Your ref: SSD 7058
File no: MC-15-1169

Re: SSD 7058 Blacktown Hospital Stage 2 Concept Proposal and Enabling Works, Marcel Crescent, Blacktown

ATTACHMENT A

Figure 19 – Indicative building massing – view from the south-east

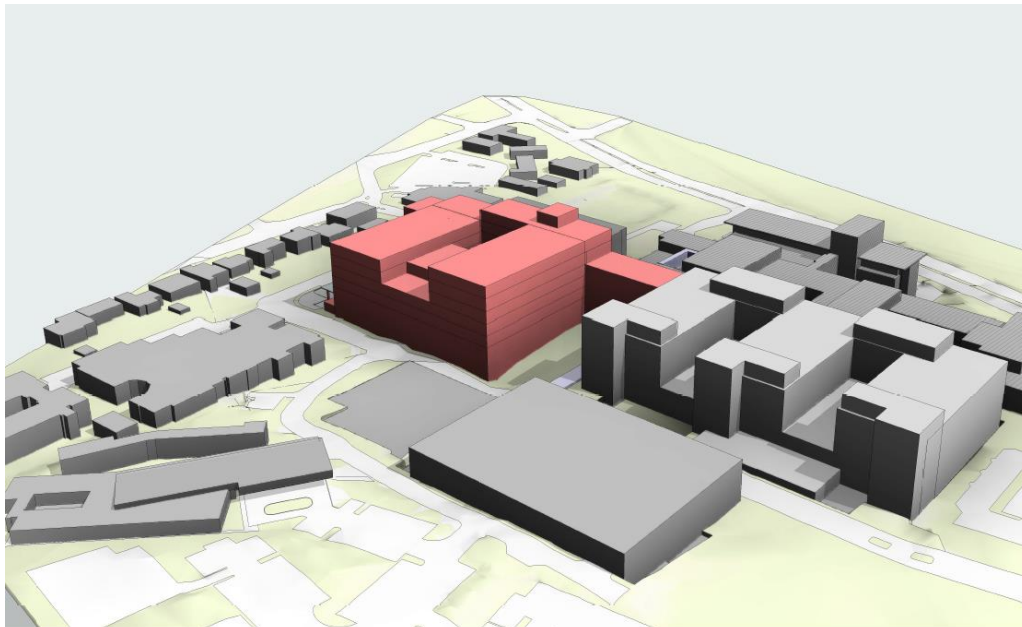
5. Given the high likelihood of the Stage 1 two storey addition and the Stage 2 multi-storey building being required to be constructed in order to respond to parking demand; these structures are recommended to be included in the 'Indicative Building Massing' study. This is to demonstrate that all current, approved and future building forms on the site are considered as a whole. It is requested that the future DAs for the Stage 2 development works comprise suitable architectural design measures to ameliorate the bulk and scale of all development works in a cohesive manner.

Figure 27 – Parking arrangements at the completion of Stage 2, including the potential multi-deck car park expansion
Source: ARUP

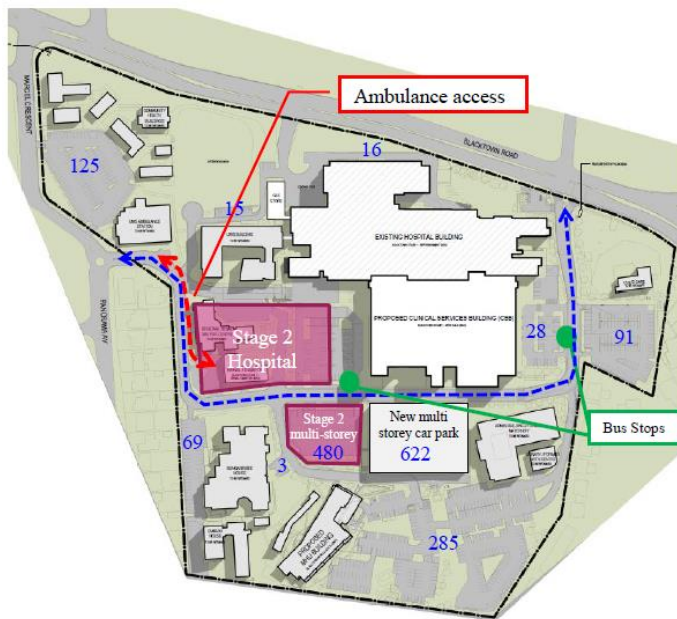
- a. The proposal indicates that separate Development Applications (DAs) will be lodged for the purpose of expanding the Stage 1 multi-car park by an additional 180 parking spaces, and for the construction of the Stage 2 multi-storey car park for 303 parking spaces. However, this approach does not ensure that these DAs will be lodged and approved to correspond with the operation of the Stage 2 building, in particular given the increased demand for on-site parking due to the likely implementation of the permit parking scheme.

The Proponent is requested to demonstrate the timing of the lodgement of these DAs and their intended construction programme to deliver these car parking structures.
